Rezoning Transportation Analysis

Petition Number: 2023-045

From: Jake Carpenter, PE

The site is located at the intersection of Park Road, a City-maintained major arterial, and Abbey Place, a City-maintained local street. A Traffic Impact Study (TIS) is not required for this site due to the site previously completing a traffic study and the minor increase in trips. All outstanding CDOT comments have been addressed.

SHEET NUMBER  
**RZ-1**

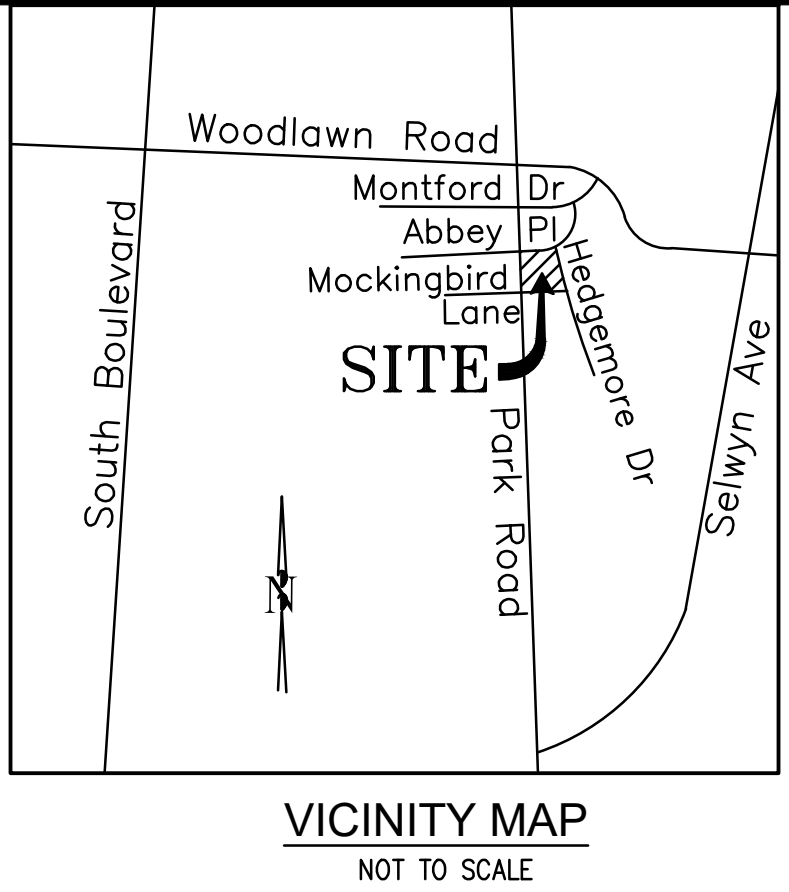
1. ~~Outstanding Comment 7/26/23 Curbline:~~

- ~~a. The future location of curb and gutters are being shown accurately for all abutting roads as specified in the previously approved rezoning.~~

~~Label and dimension the curb and gutter from the centerline for each road on the site plan.~~

~~**Clarifying Comment 8/24/23:** Site plan needs to show dimension of future back of curb from centerline.~~
